**RESPONSE TO SUBMISSIONS REPORT
NEPEAN HOSPITAL STAGE 2 REDEVELOPMENT
SSD DA 16928008**

PART A – MAIN REPORT

SSD DA 16928008 NEPEAN HOSPITAL STAGE 2 REDEVELOPMENT DERBY STREET, KINGSWOOD

Figure 21 - Proposed Drop-off area and access driveways

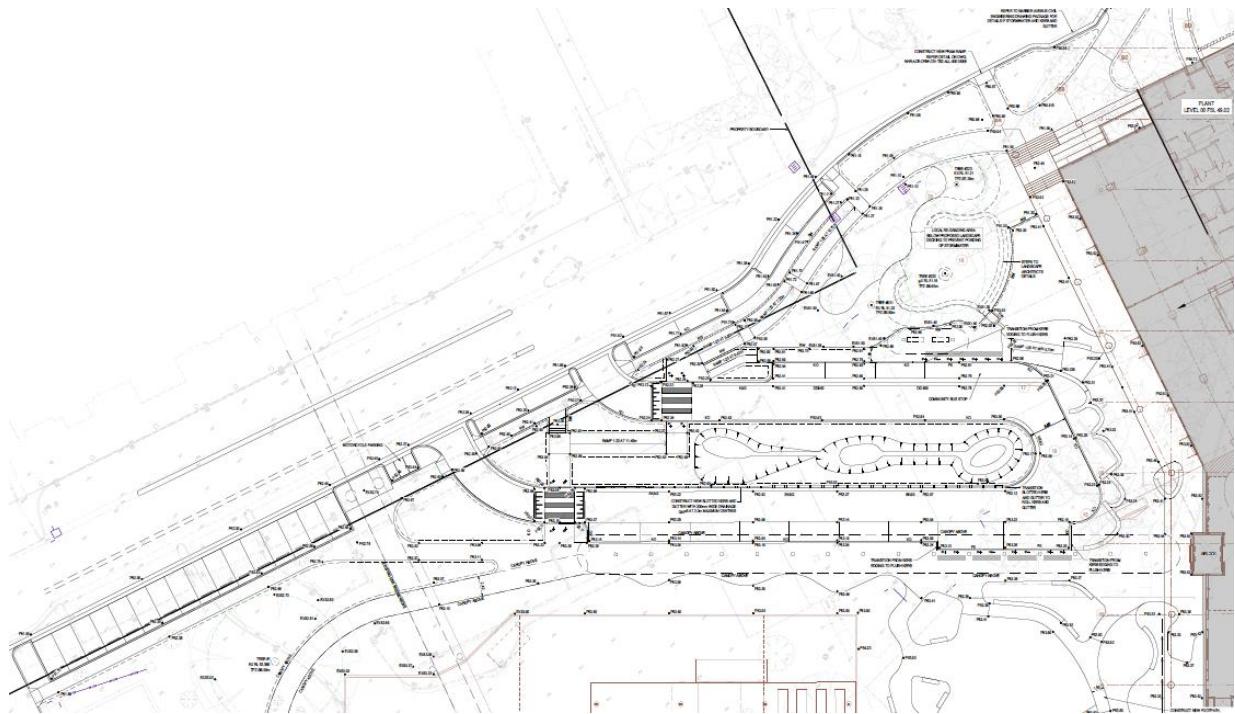
One of the key issues raised in the Penrith City Council submission relates to the loss of 43 parking spaces on Barber Avenue to cater for the new entry and drop-off area for the Stage 2 Building, along with the design of that roadway and its relationship to Barber Avenue.

The updated design is included as part of the Acor drawings at **Appendix E**.

Level 4 and 8 Roof - Plant Room Screening

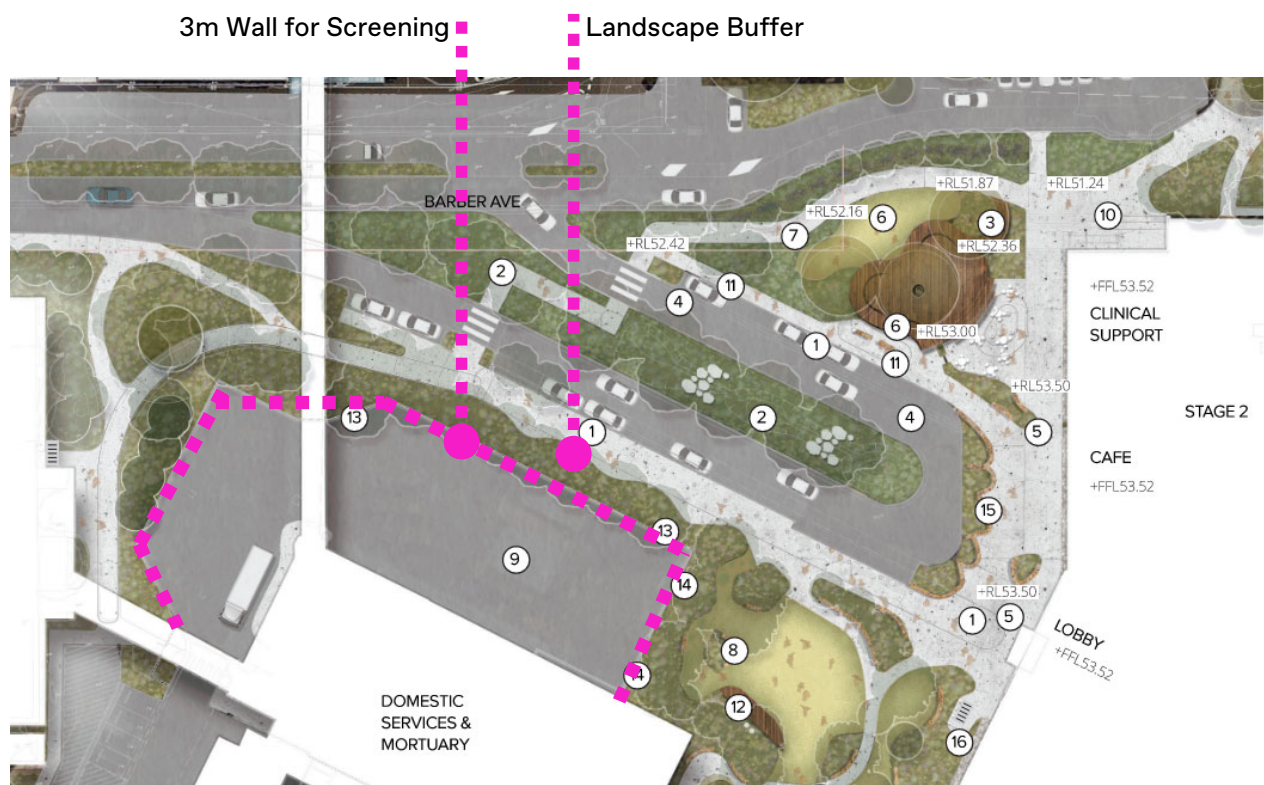
The plans are to be amended to include screens for the rooftop plant and utilities to minimise the visual impact of these structures.	<p>As above, BVN has advised that refinement has occurred at the Design Development phase. This has resulted in all rooftop plant rooms being fully enclosed with louvres which are generally integrated into the tower façade systems. This provides for a consistency of the facades where large louvre areas are required for plant rooms on Level 4 and the Level 8 roof. These closely tie-in with the plant room screening implemented for Tower 1.</p> <p>Rooftop plant rooms have been set back from the building edges, and employ dark-grey-coloured louvre screens to reduce potential visual impacts.</p>

Northern Facade Updates

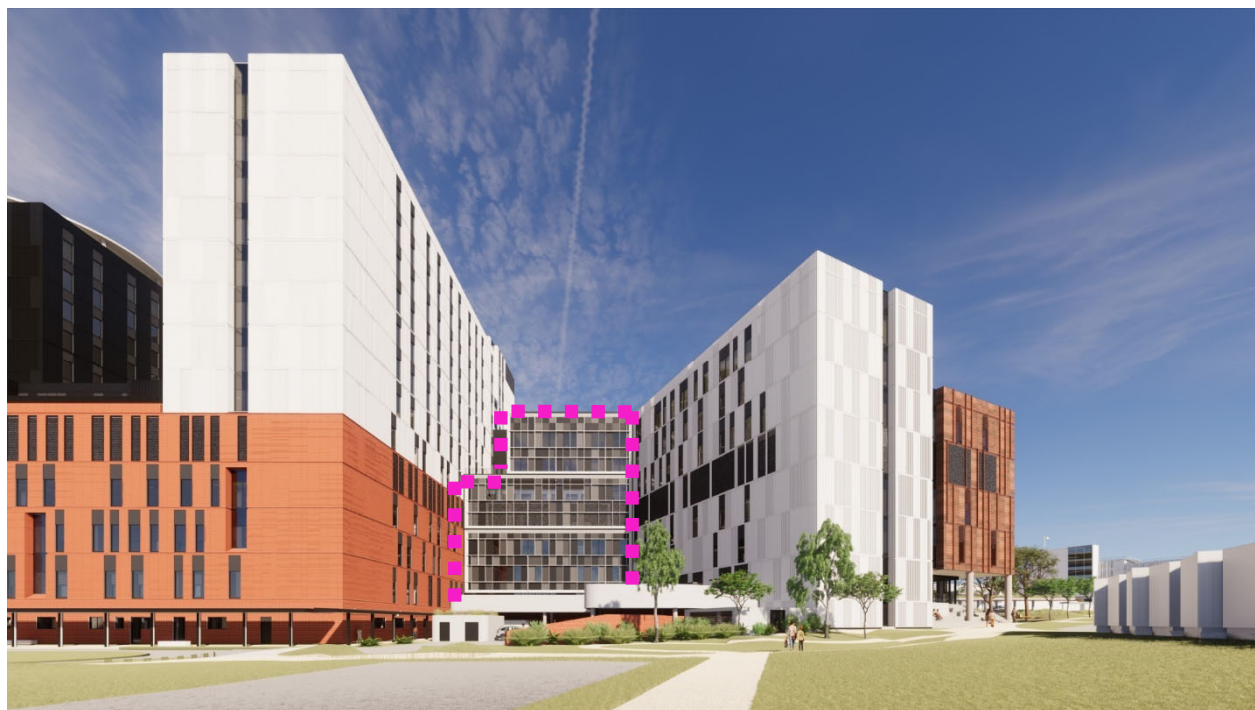
Issue	Response
Built Form	
The southern and eastern elevation plans depict facades that would benefit from the use of colour or material change to create visual articulation of the building bulk similar to the eastern facade. Consideration should be given to integrating colour and altering materials to create visible building articulation and to break up the blank facade.	<p>BVN has provided a detailed response in a revised Architectural Design Statement addressing relevant commentary made in the submissions – see Appendix C.</p> <p>In short, to summarise, following the State Design Review Panel (SDRP) process and commentary for further façade articulation and colour and materials changes, BVN has further developed the design as part of the Design Development phase.</p> <p>BVN advises that for overall design consistency it was important for Tower 2 to tie into the façade language of Tower 1 with the overall intention to create one seamless building especially along the southern and eastern facades.</p> <p>The main focus for façade variation and introducing change in materiality remains the Western façade, clearly marking the new hospital entry.</p> <p>The overall number of façade types for both buildings is minimised for clarity and to suit the required modulation of the clinical planning, and to accommodate internal planning changes that occurred during Design Development.</p> <p>The southern and eastern tower façades are made up of windows and metal cladding panels and seeks to provide textural variability using a mixture of profiled/ribbed metal cladding in combination with a smooth flat panel. To provide depth and visual relief, the façade system is further articulated with the use of recessed “urban markers” which respond to the internal planning. This is depicted in the BVN response at Appendix C.</p>
